10 Hill Rise JP

Sent: ✓ 21 June 2012 09:34
To: Planning
Subject: Welwyn Hatfield Council Online Planning - Comment

Application Number: S6/2012/0631/FP

Dra. Title: Site Plan

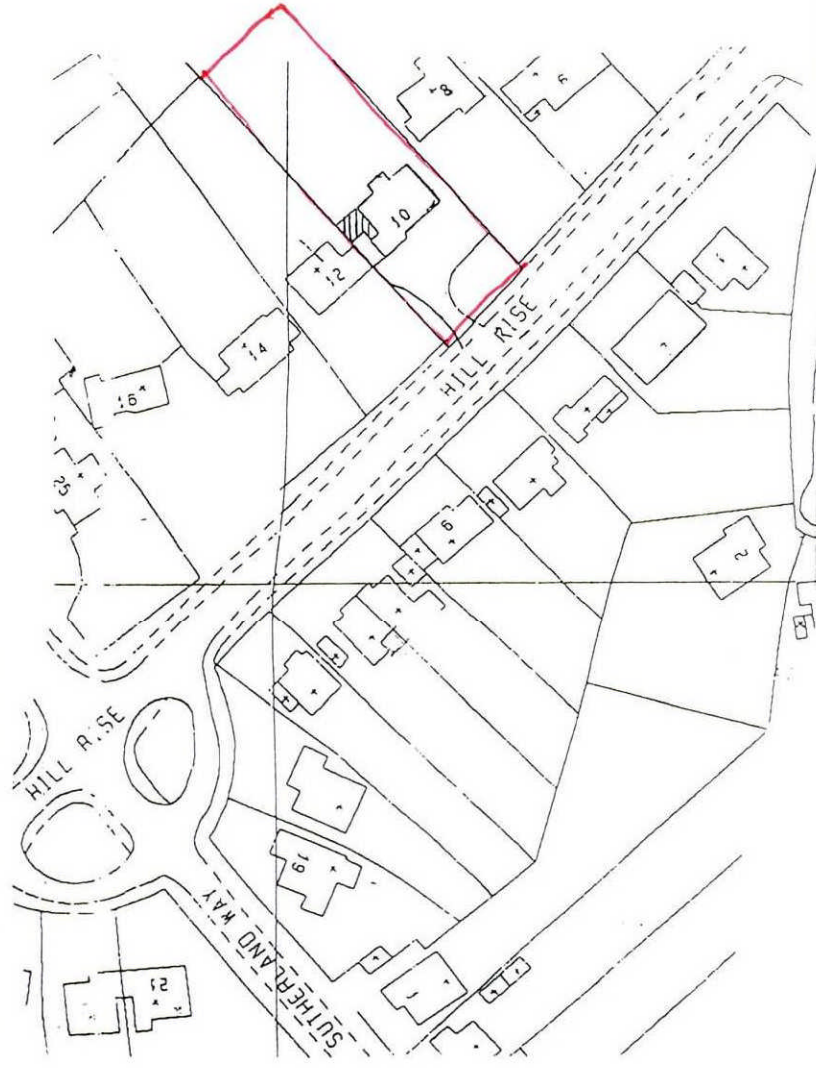
Comment: The existing single skin brick 'garage' was built on top of the concrete boundary retaining wall. We assume the extension will be stepped back (not shown on the plans) as the existing boundary retaining wall may possibly not support a new structure. Also confirm that the existing shed will be demolished otherwise the light to 12 Hill Rise will be severely reduced .
